Meeting note

File reference	EN020015
Status	Final
Author	Siân Evans
Date	19 July 2017
Meeting with	National Grid
Venue	Temple Quay House
Attendees	The Planning Inspectorate Chris White (Infrastructure Planning Lead) Tracey Williams (Case Manager) Siân Evans (Case Officer) Hannah Pratt (Senior EIA and Land Rights Advisor) Alison Down (EIA and Land Rights Advisor) Dave Anthony (Lawyer) National Grid Eloise Frank (Project Engineer/ DCO Manager) Jacqui Fenn (Senior Consents Officer) Annette McNally (Lead Lands Officer) Simon Best (Internal Legal) James Parker (External Legal) Andrew Connolly (Lead Project Manager)
Meeting objectives	North Wales Connection Project update
Circulation	All attendees

National Grid Construction Plans Chapter 4 – Figure 1

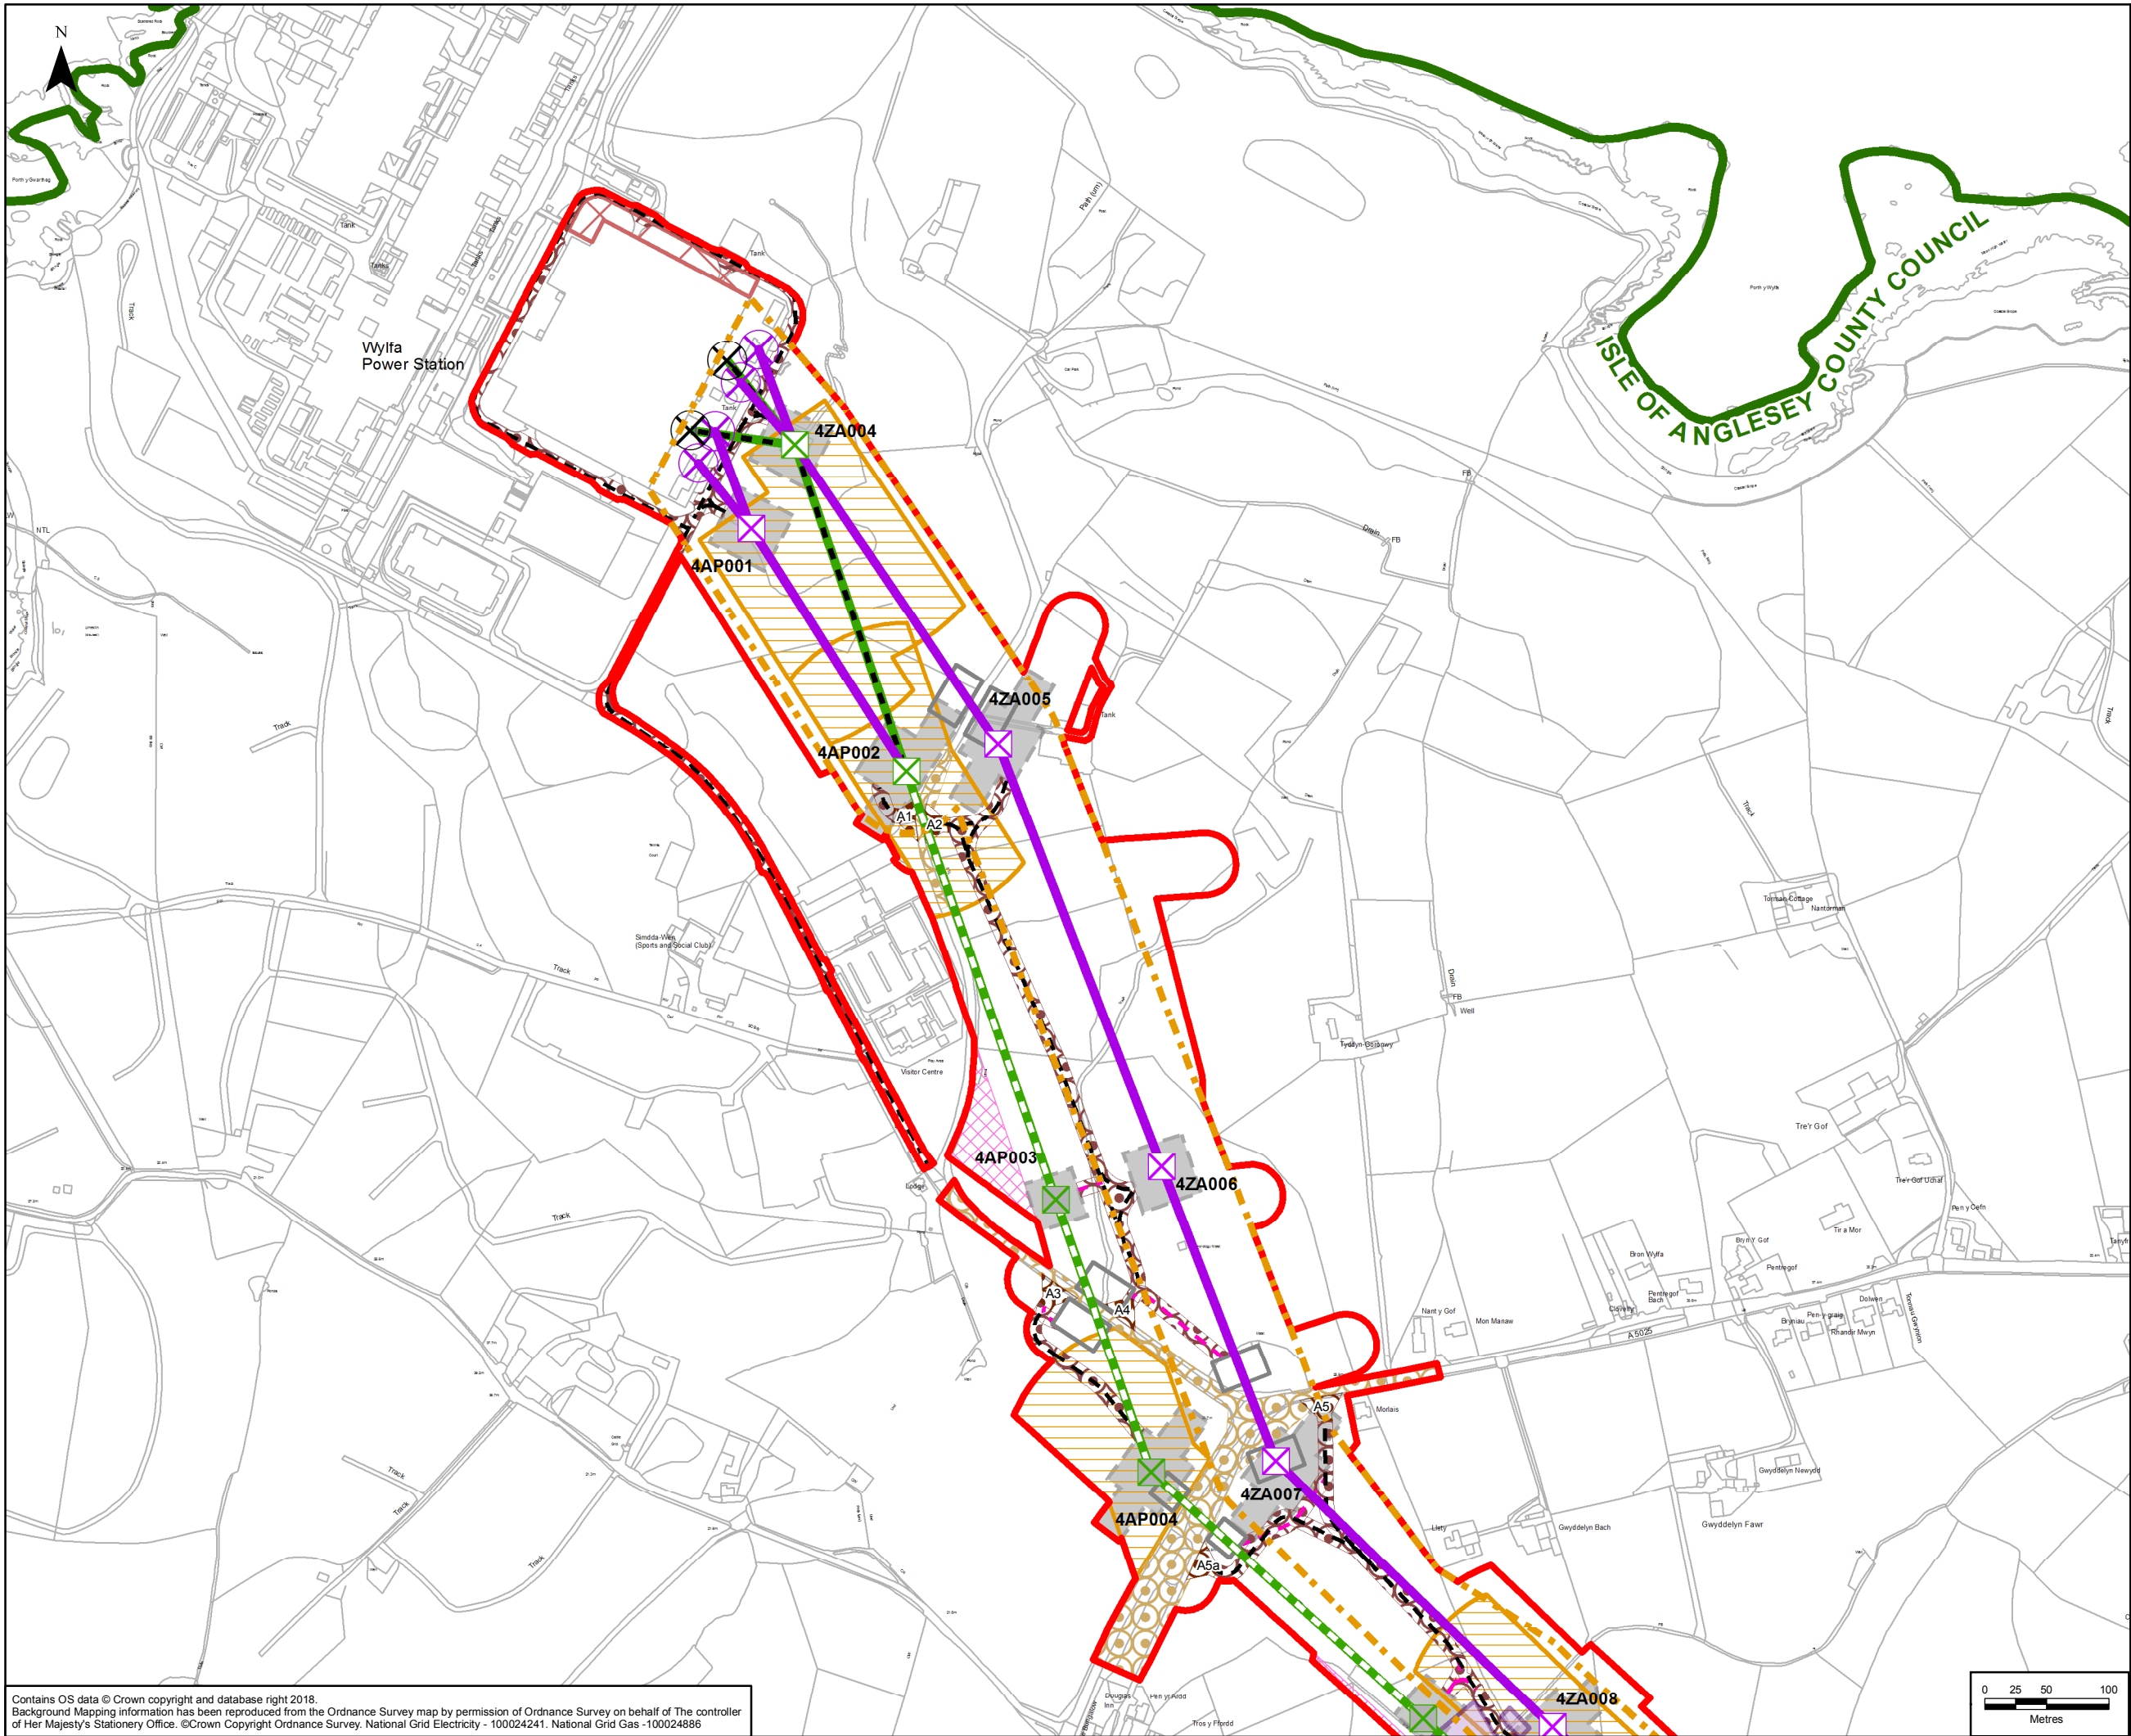
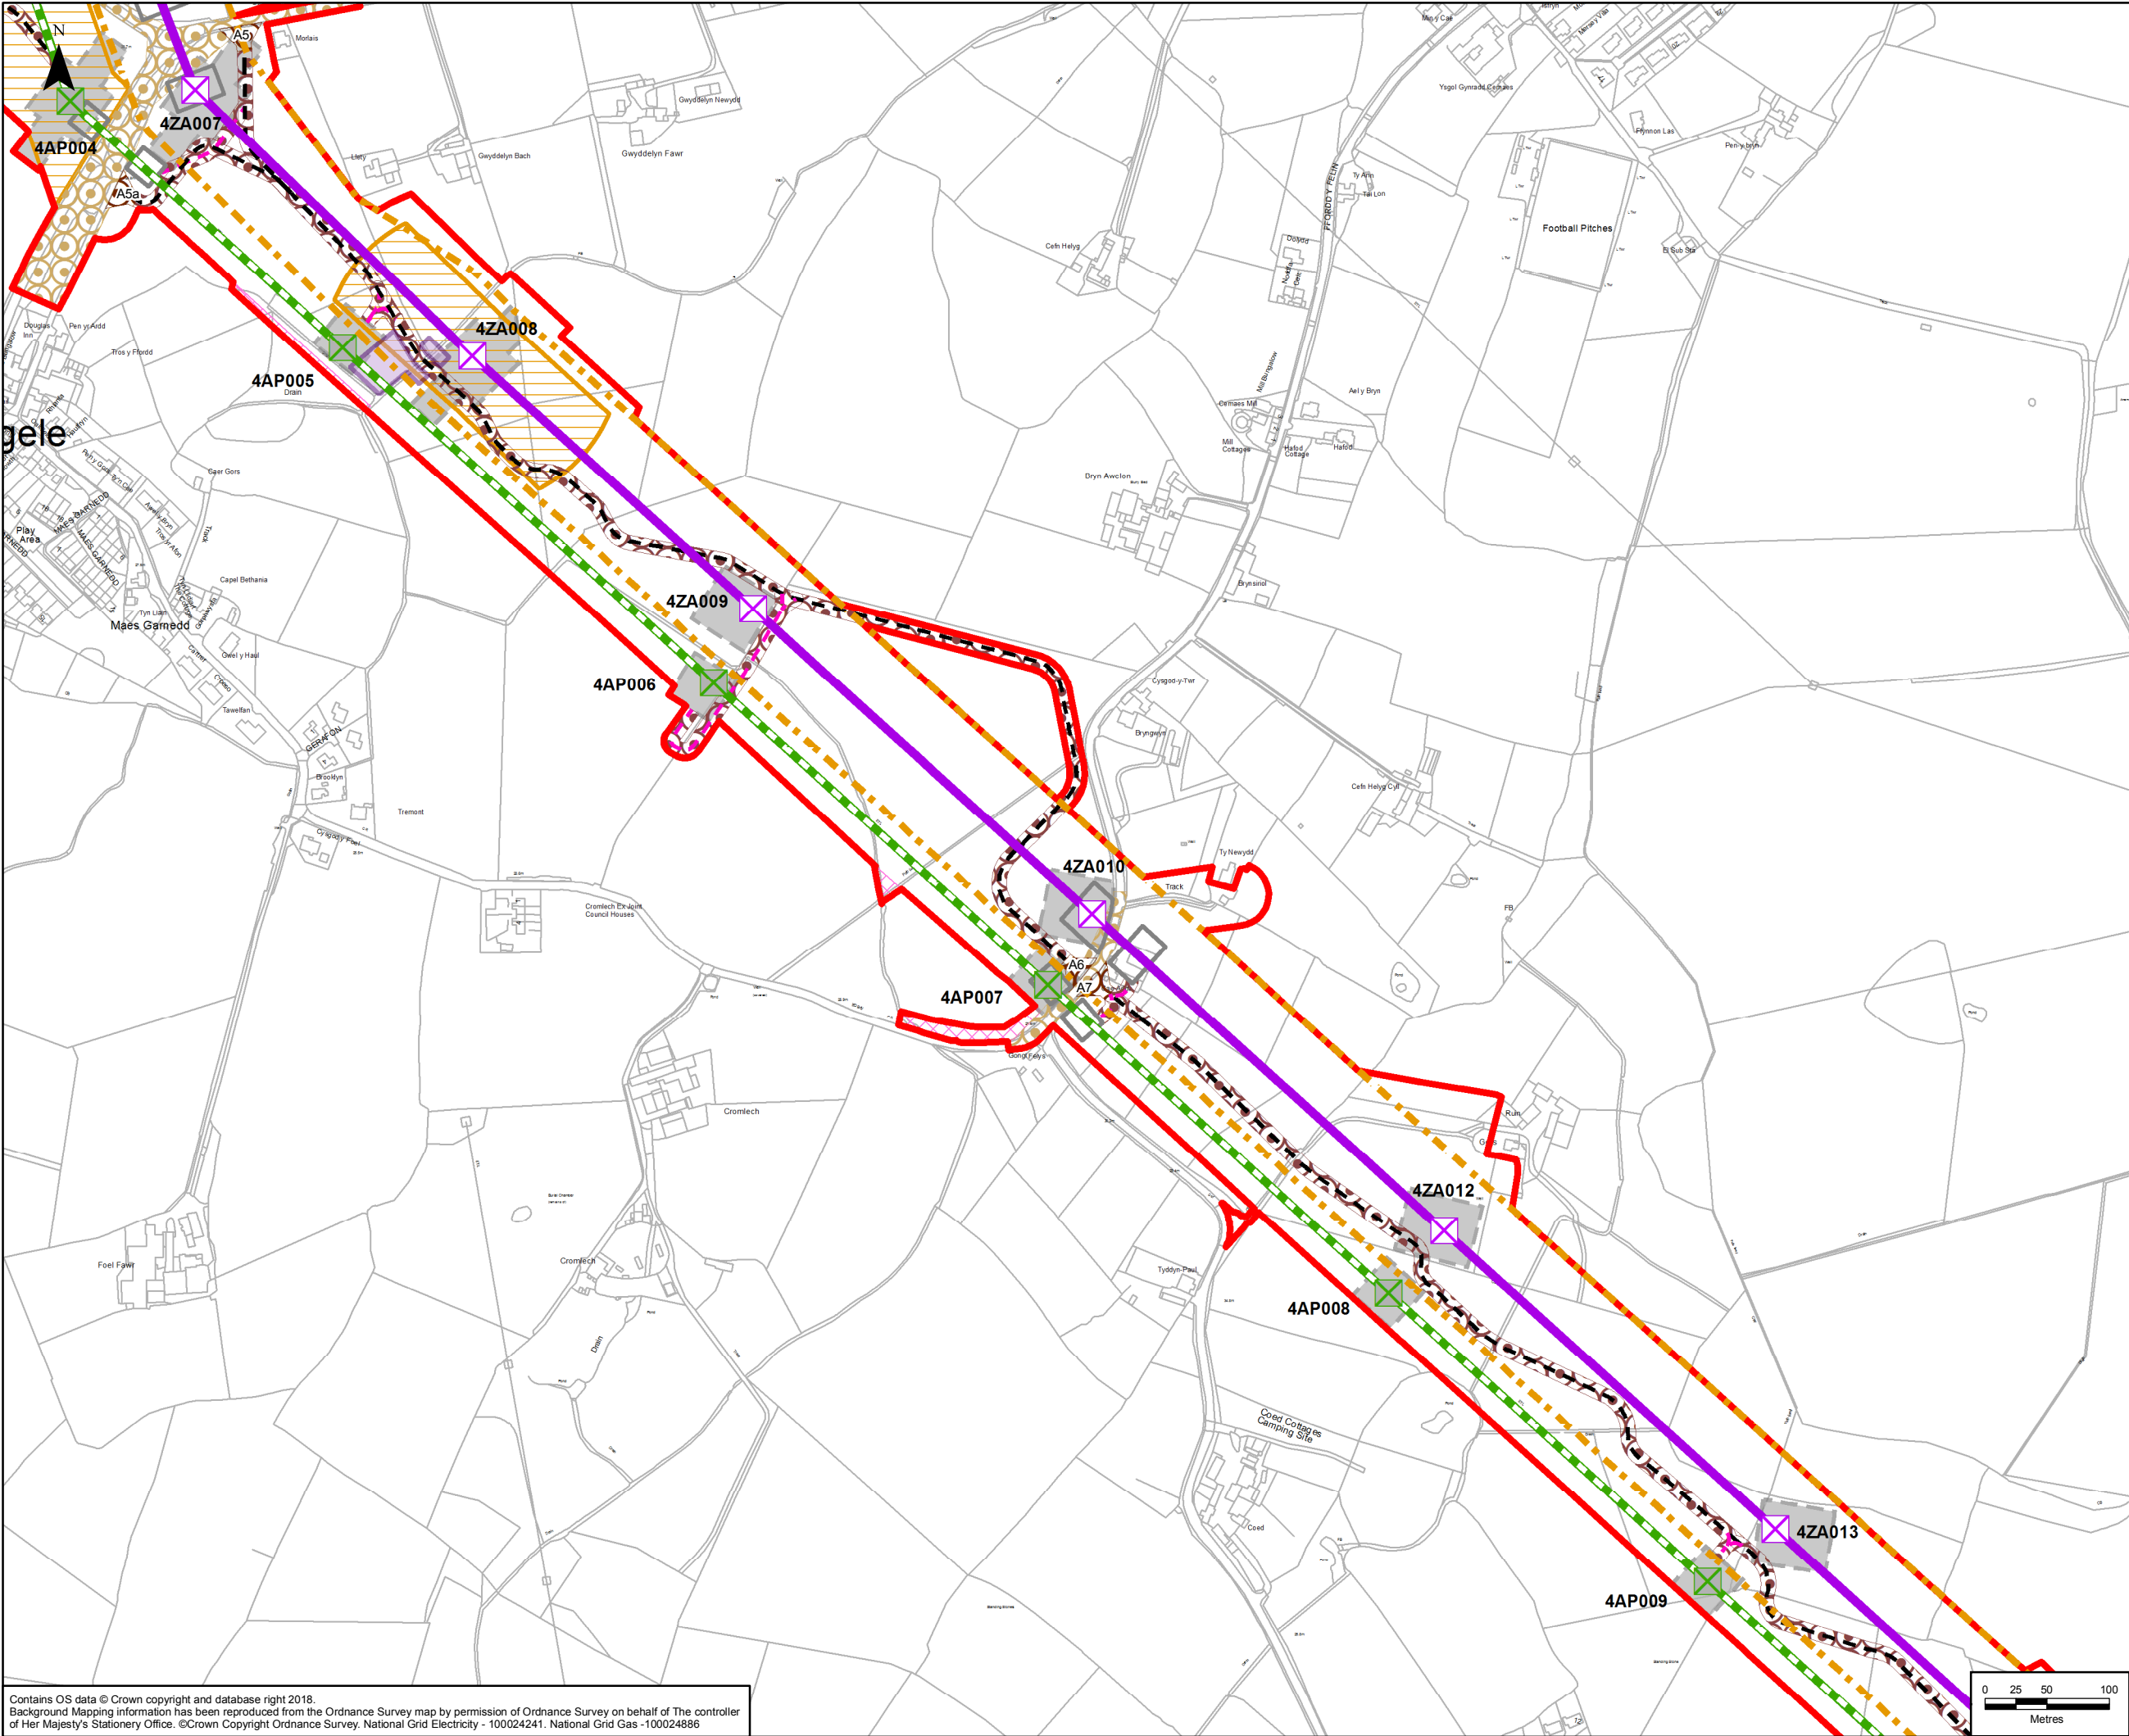
- The Works Plans show a number of accesses along the route. The Inspectorate queried what works are required and whether they need to be numbered within the authorised development or included as associated development.

- The 'new gantry' (full line tension) and 'new lattice pylon' symbols used on the Works Plans are very similar. It would be helpful if different symbols are used to clearly differentiate between the two.
- The Inspectorate advised the Applicant to note that at Acceptance all of the plots in the Book of Reference are checked against the Land Plans.
